Our reference: FIL11/9583:DOC11/57445:PB  
Contact: Mr Peter Bloem, (02) 4224 4100

**EXHIBITION OF ENVIRONMENTAL ASSESSMENT FOR DEVELOPMENT OF A  
DENTAL HOSPITAL KIORA RD – MIRANDA**

## **ATTACHMENT 1 - EPA COMMENTS ON EXHIBITED EA**

drawing number :
2.02
issue :

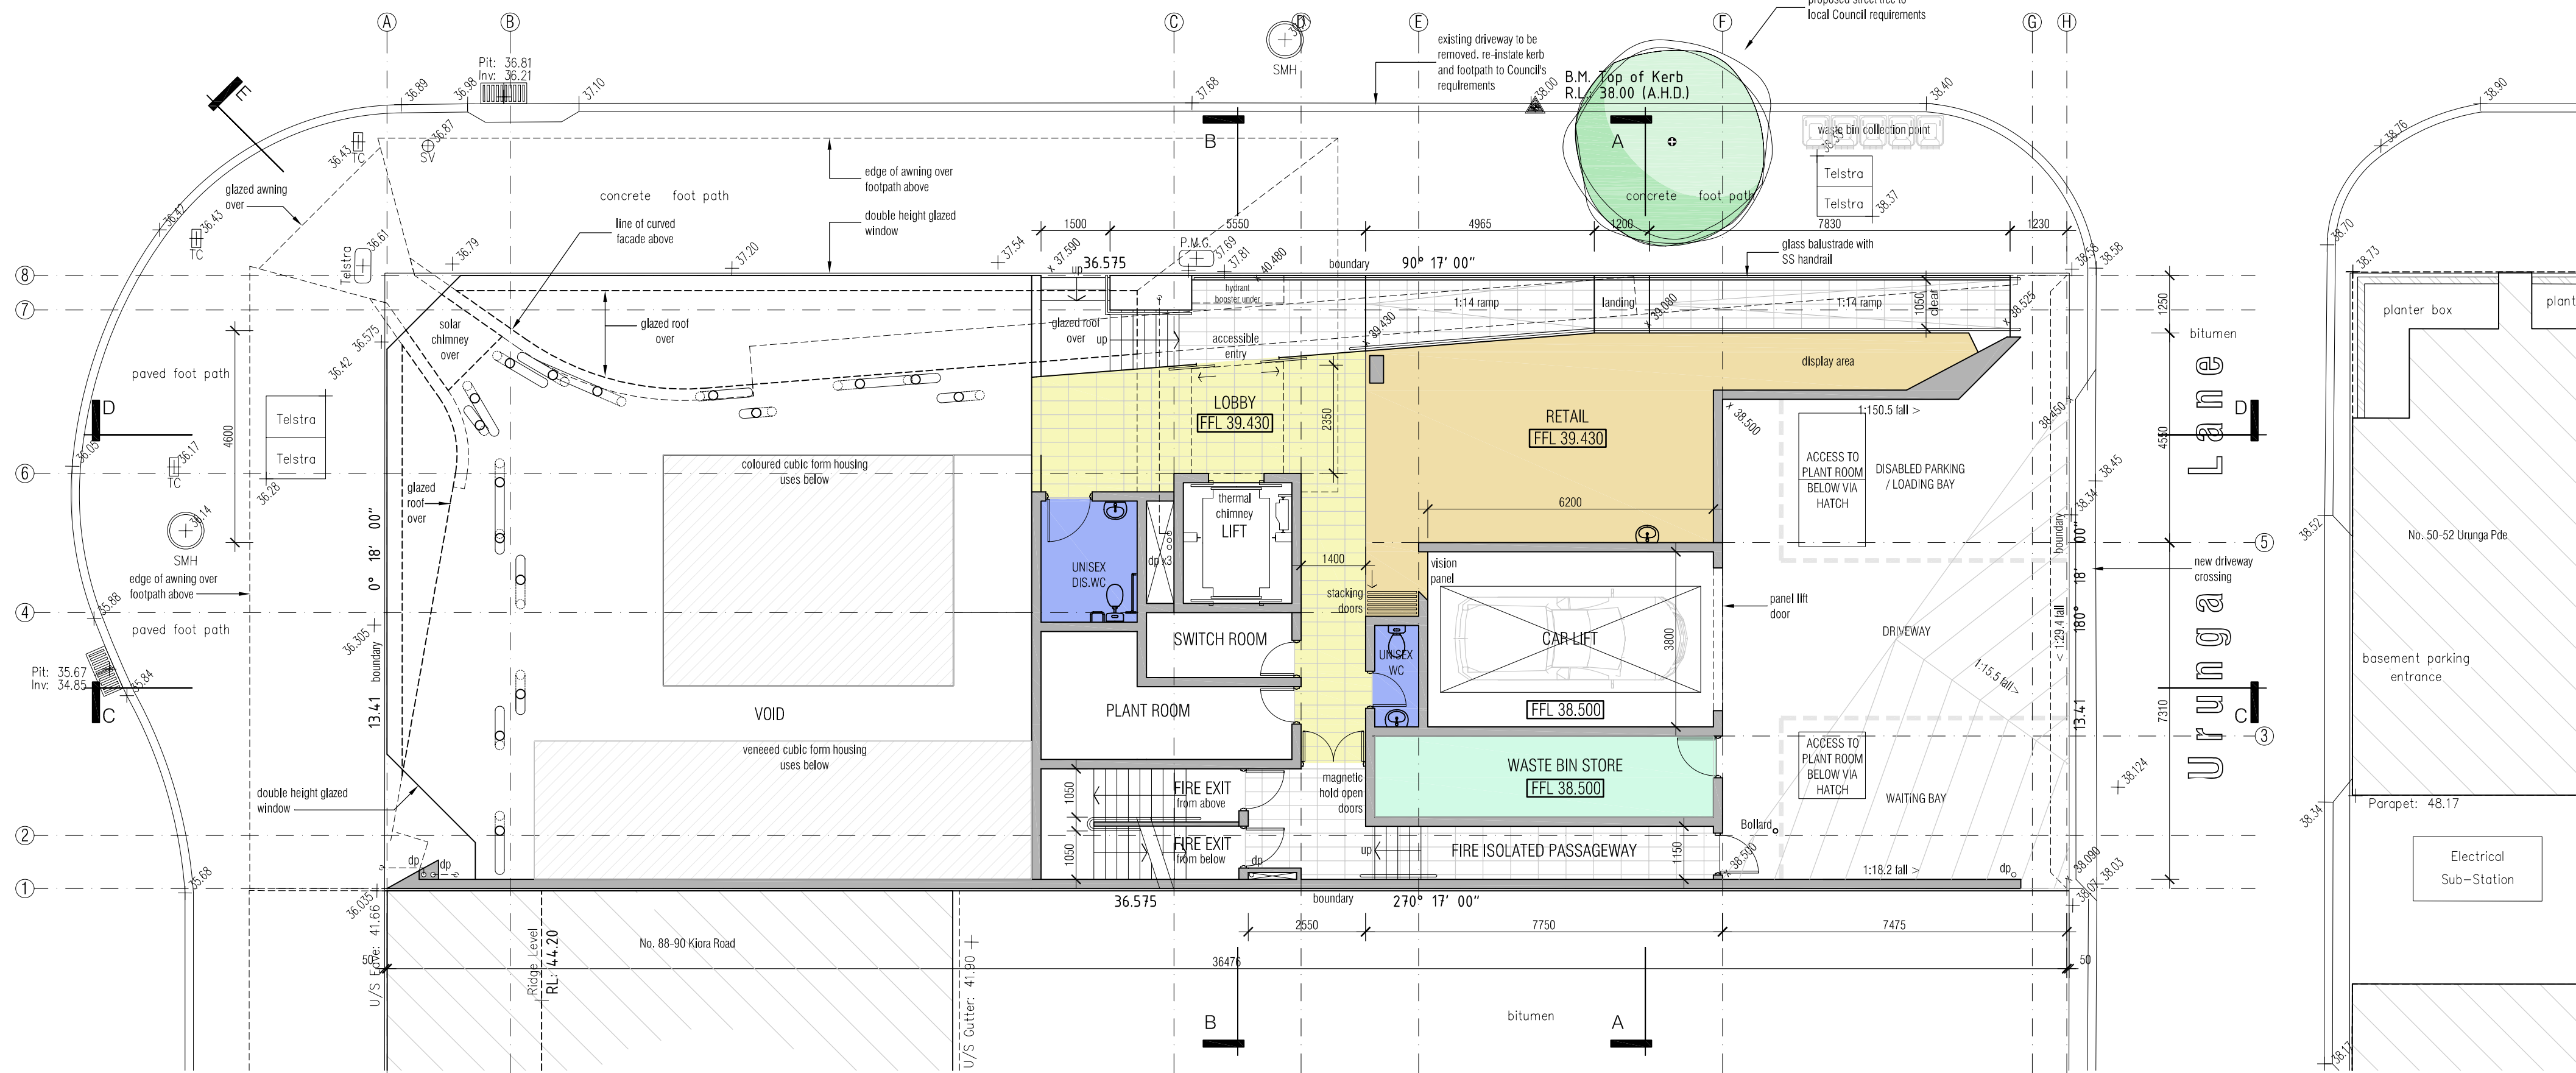
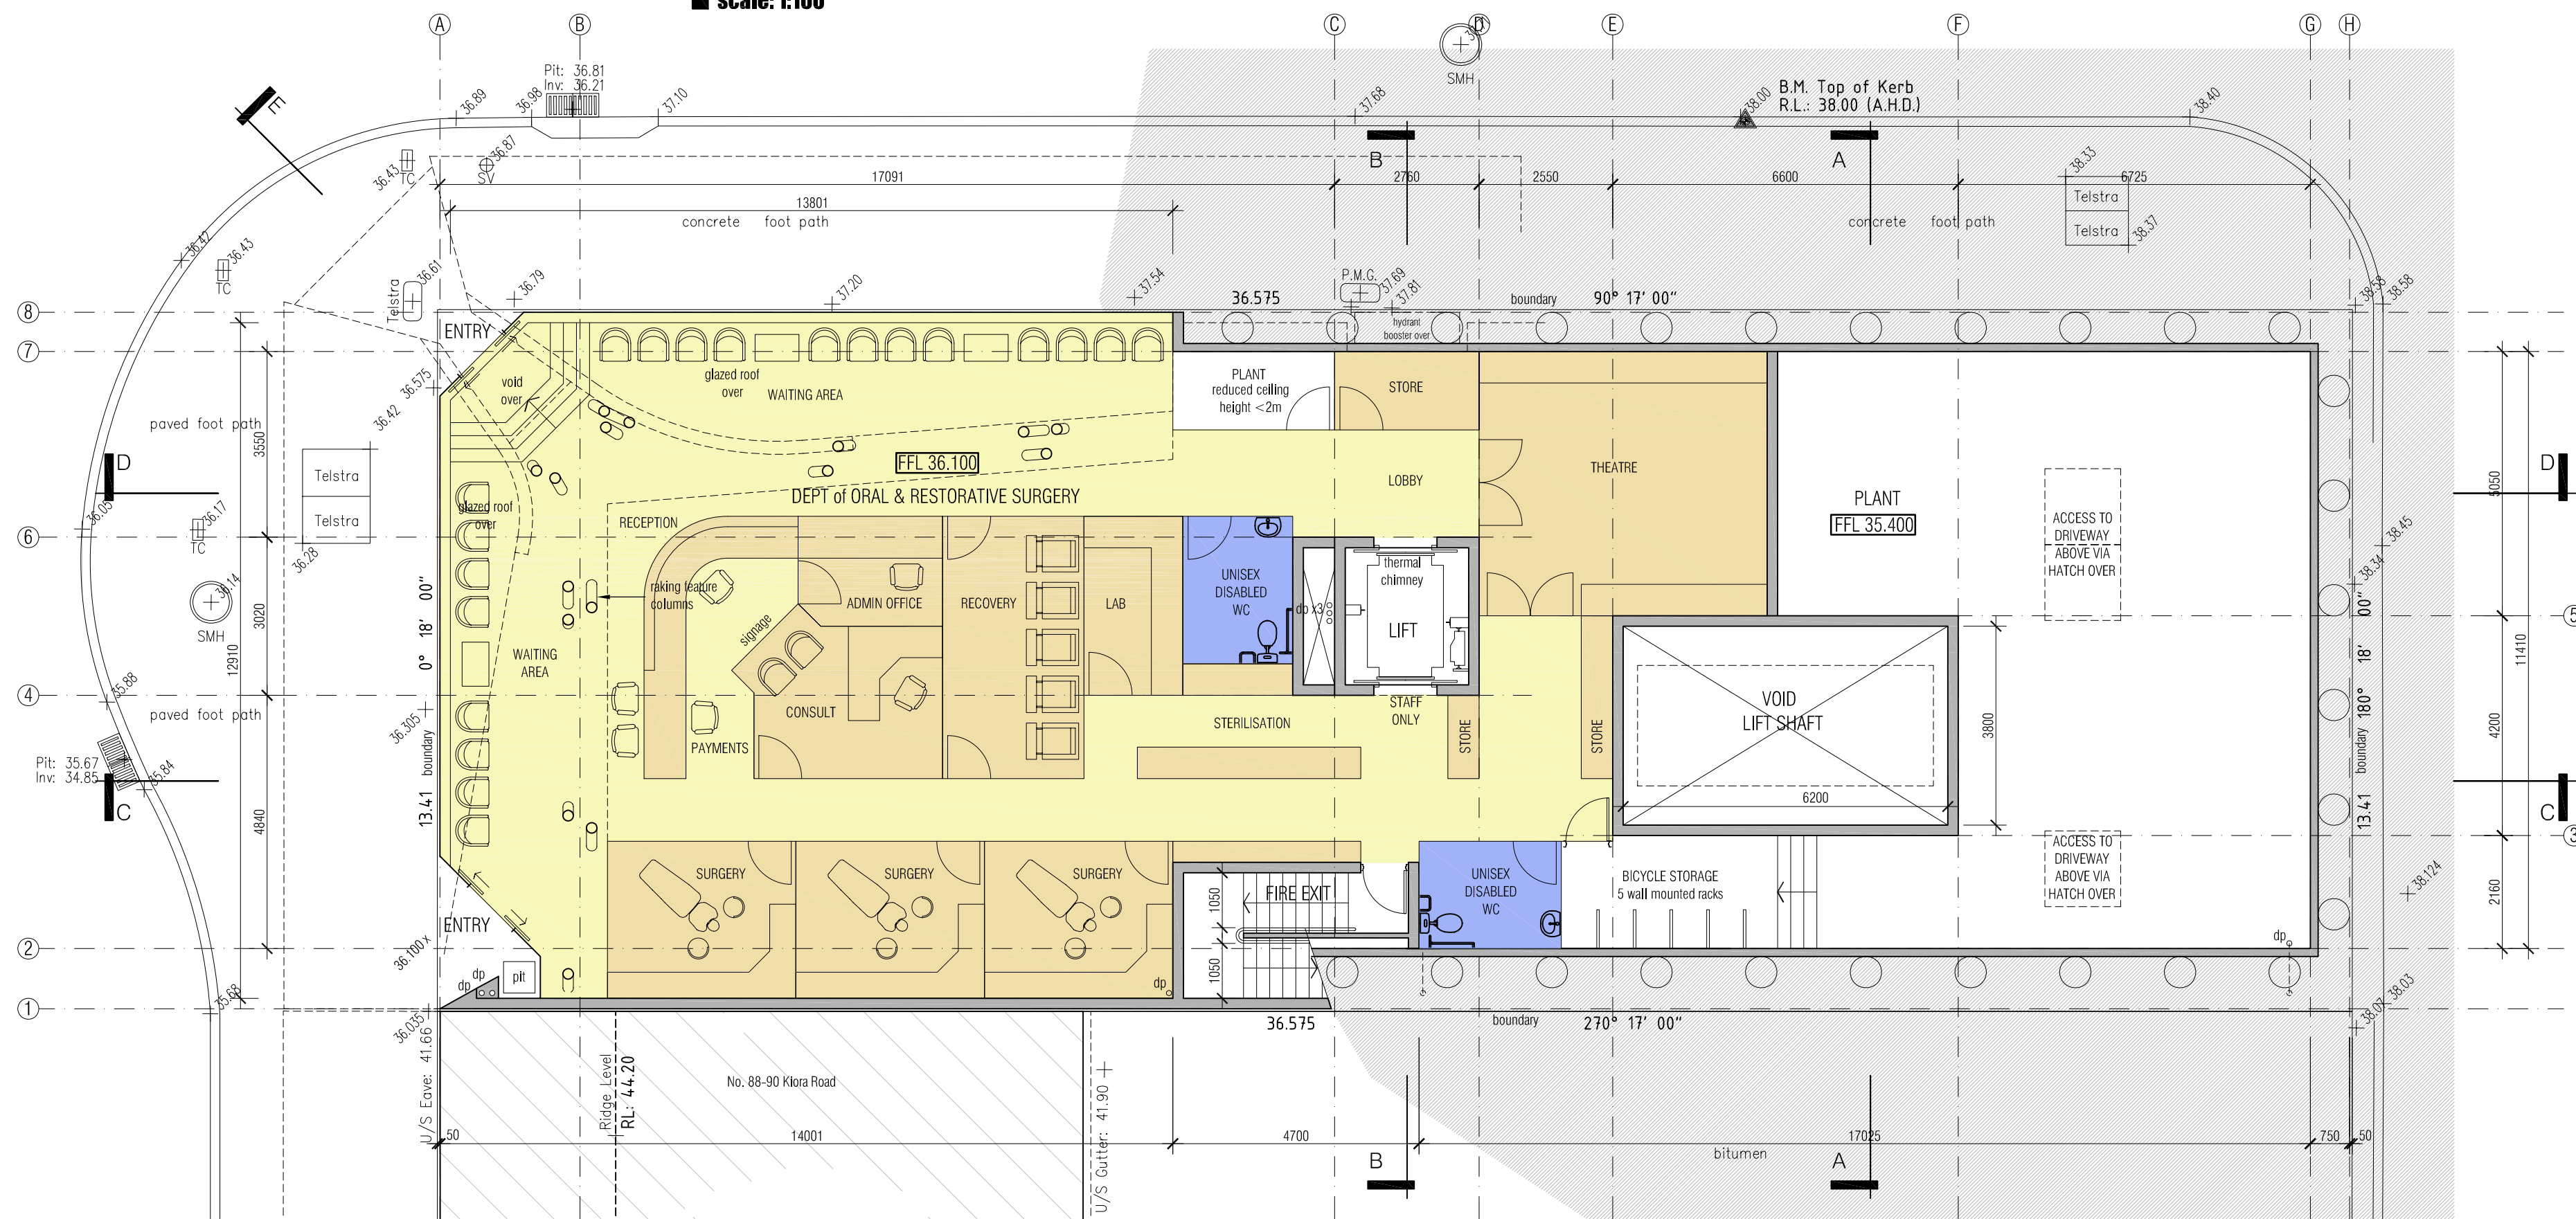
The EA states there will be a Department of Radiology on Level One and the floor plans appear to indicate several X-ray units. It is unclear from the EA, however, on the exact nature of any radiation apparatus that will be installed.

In addition, the structure of the radiology department must ensure that members of the public do not get more than 1 mSv of radiation a year from x-ray apparatus and occupationally exposed persons must not get more than 20 mSv a year. This may require a shielding assessment to be carried out. *Radiation Guideline 7* can provide guidance on radiation shielding design assessment and verification requirements. EPA does not accredit persons to carry out shielding assessments.
